BR/244/20/PL

The Beach Hotel, former Mud Club Waterloo Square Bognor Regis PO21 1SU

Redevelopment into 11 No. 2 bed apartments & 2 No. commercial units (A1 Retail or A3 Restaurant/Cafe) (resubmission following BR/282/19/PL

Drawing Number / Revision:
18.103.201

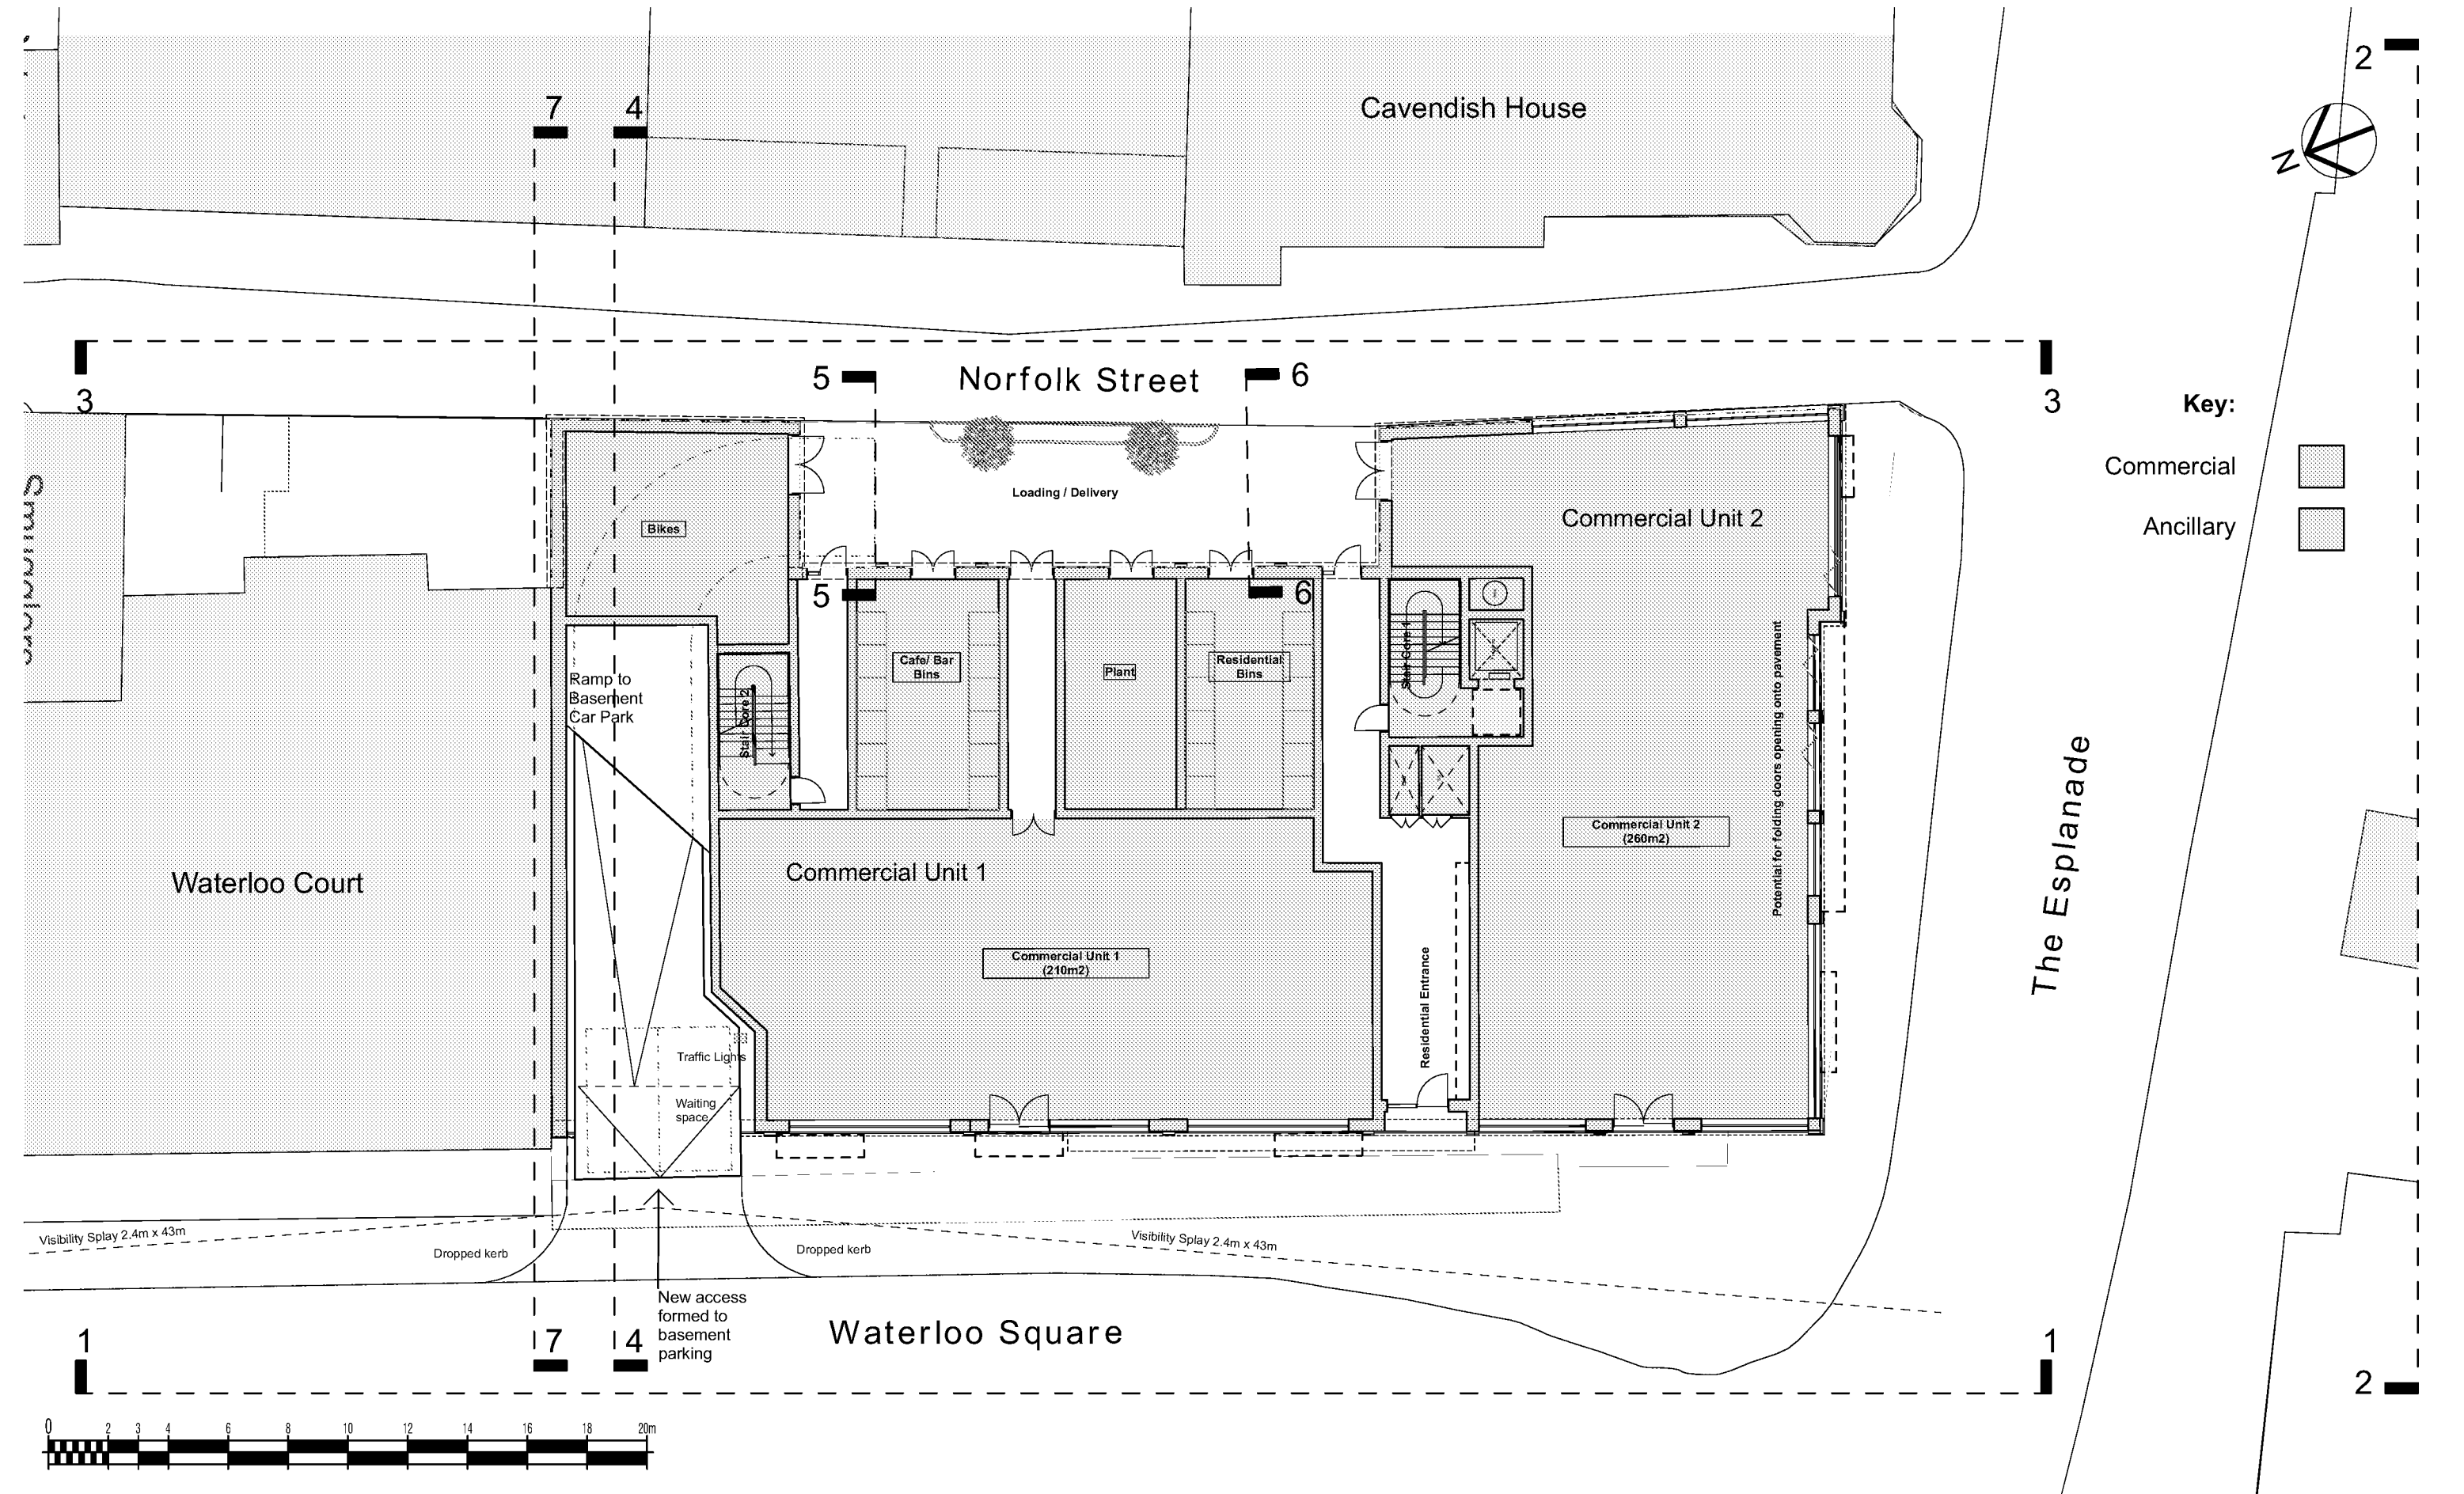
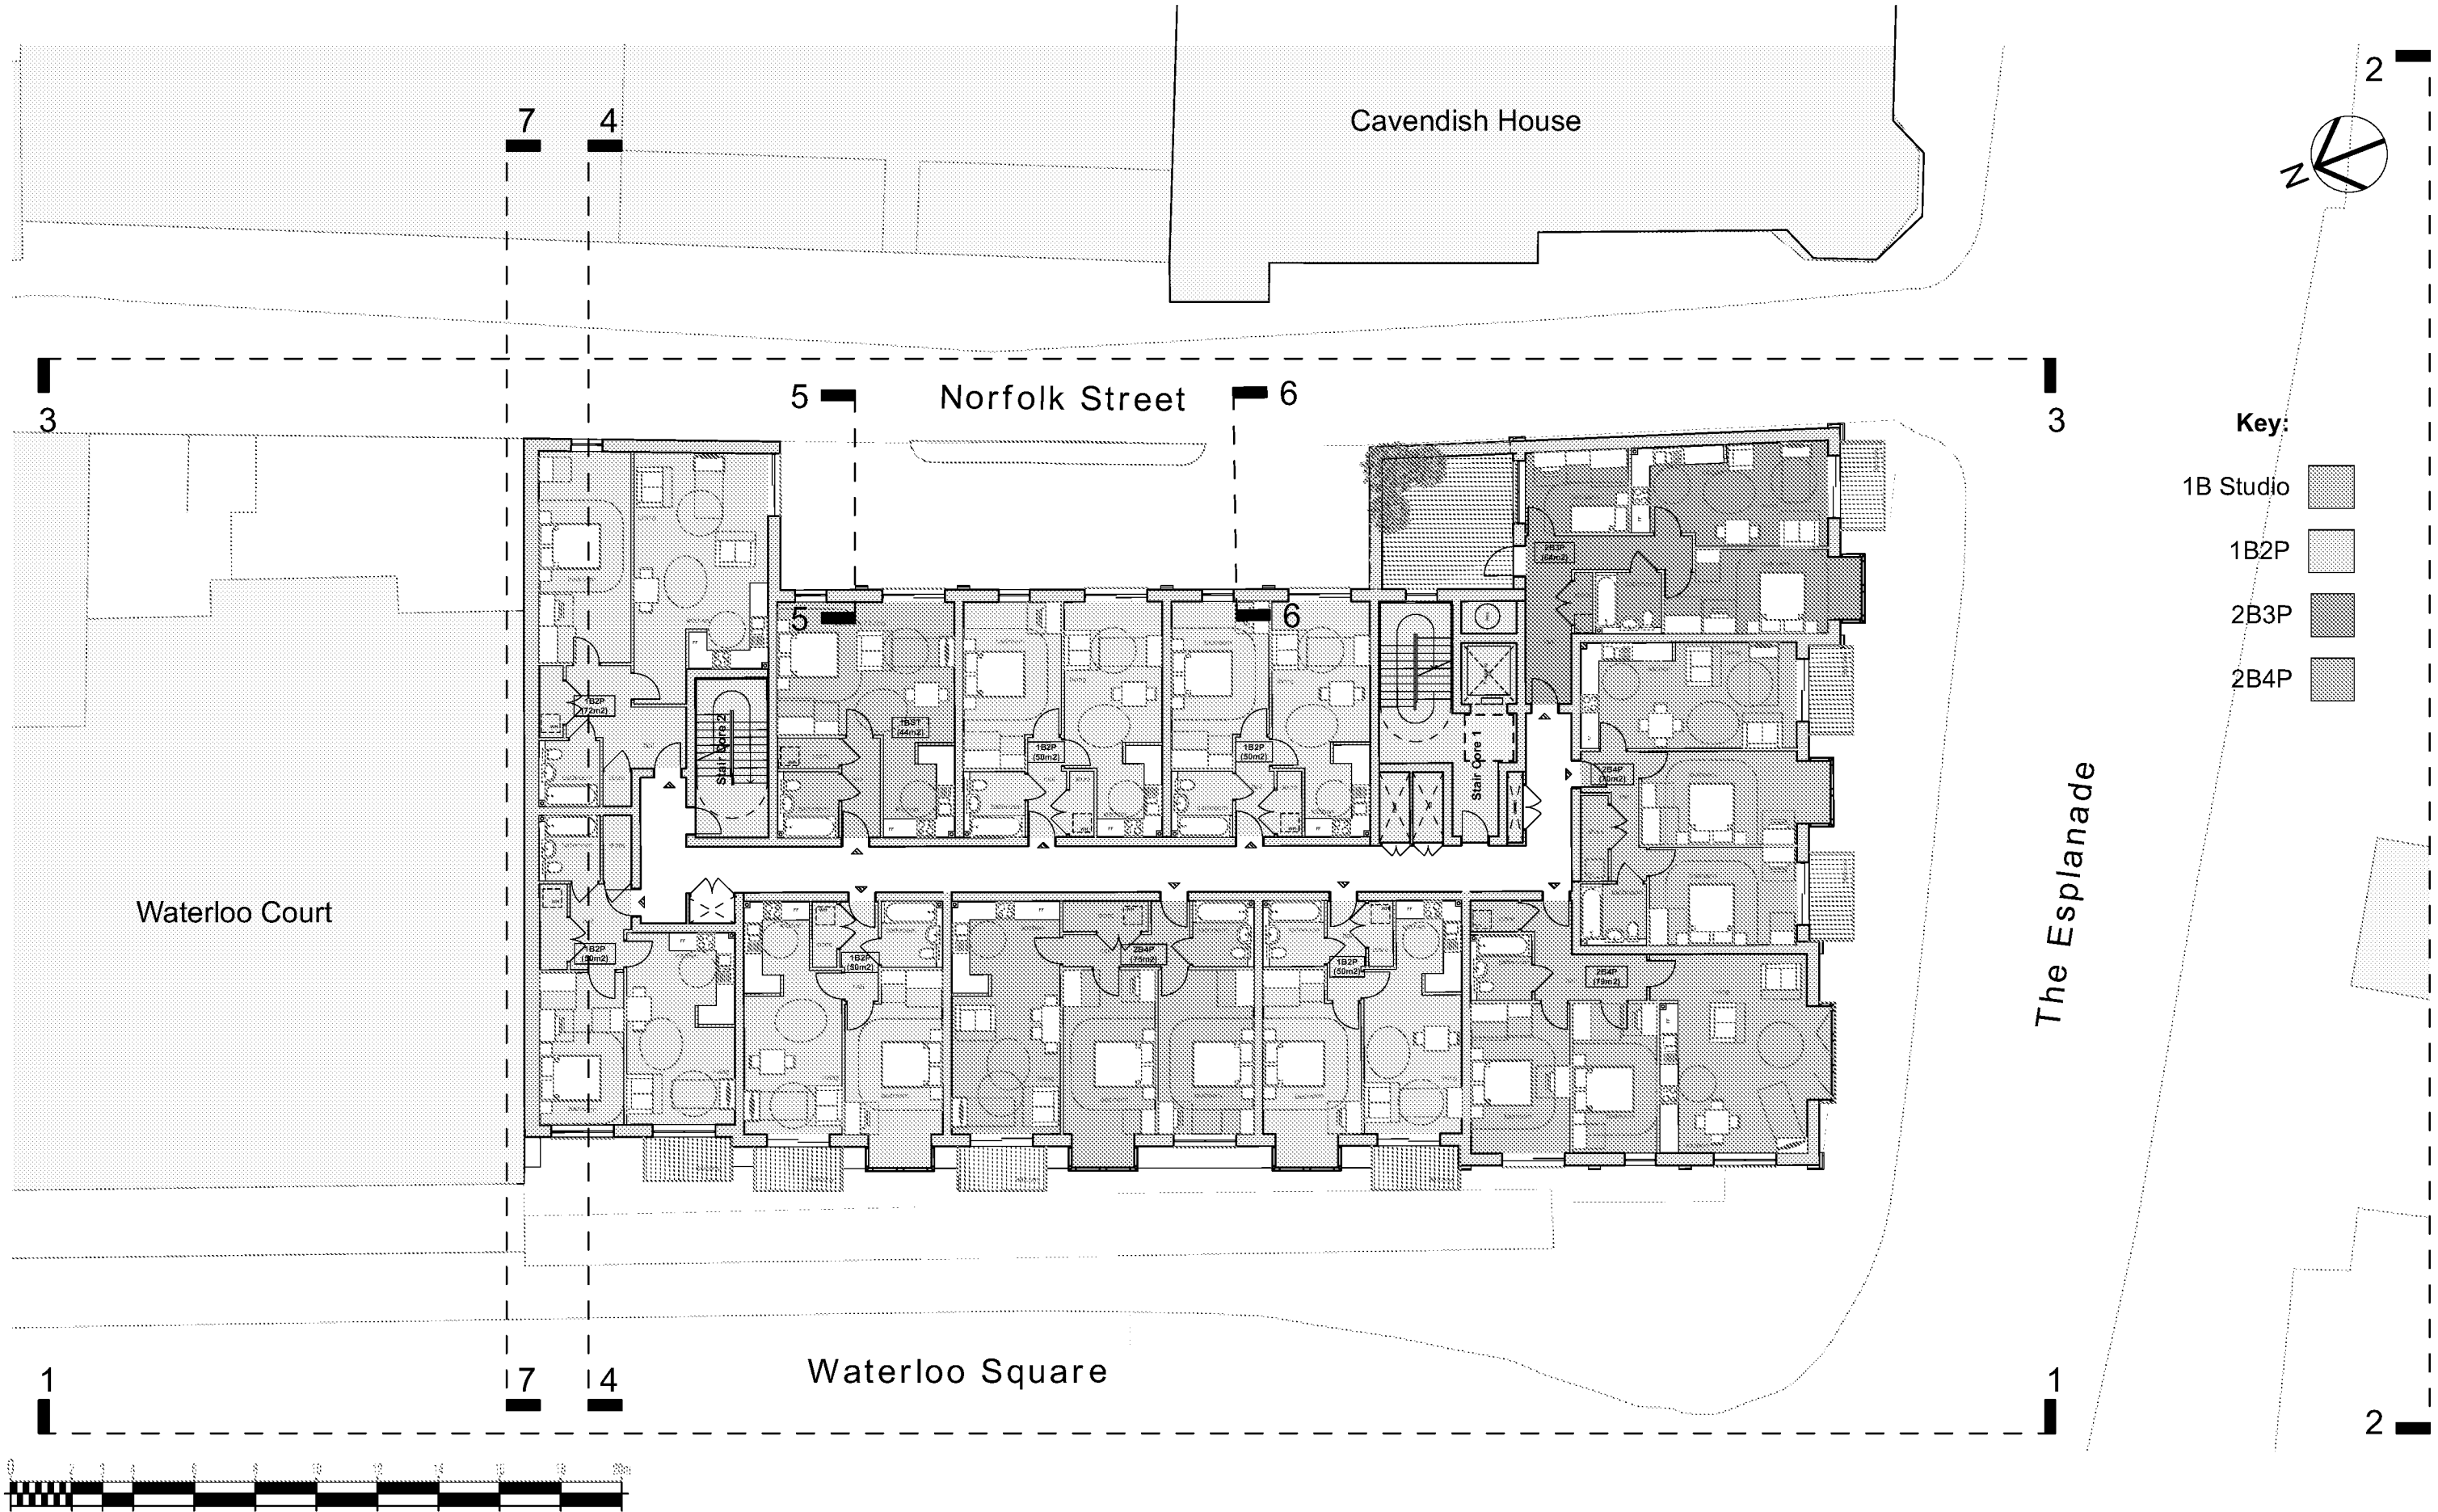
It is positive to note that the proposal maintains the existing building line along Waterloo Square and the Esplanade. Further the retention of a ground floor retail/commercial element around the junction with the esplanade can be supported as it will maintain the previous use of part of the site and encourage visitors into this part of the town.

The current scheme is also considered to reflect a number of elements found within the conservation area such as the use of bay windows and the design of the balconies. Furthermore, the corner of the western/southern elevations is such that it could form a focal point on The Esplanade, as the previous building did. This is a definite positive feature, especially the dome which is reflective of both another building in the town, and a former building which was located close by. The success of such a scheme will depend upon the materials, colours and details chosen. If minded to approve the application, please condition details of all materials, windows/doors (including details of their positions within the openings), external colours and details of cornices and parapets etc.

The new building is also now closer in height to the neighbouring buildings, but still remains between one and two stories higher than those buildings in the conservation area. Development of this height would be contrary to the established character, but as previously mentioned would form a focal point in this specific location, and would therefore, on balance, be acceptable. However, it should be noted that this should not form a precedent for elsewhere in the conservation area if the application is approved.
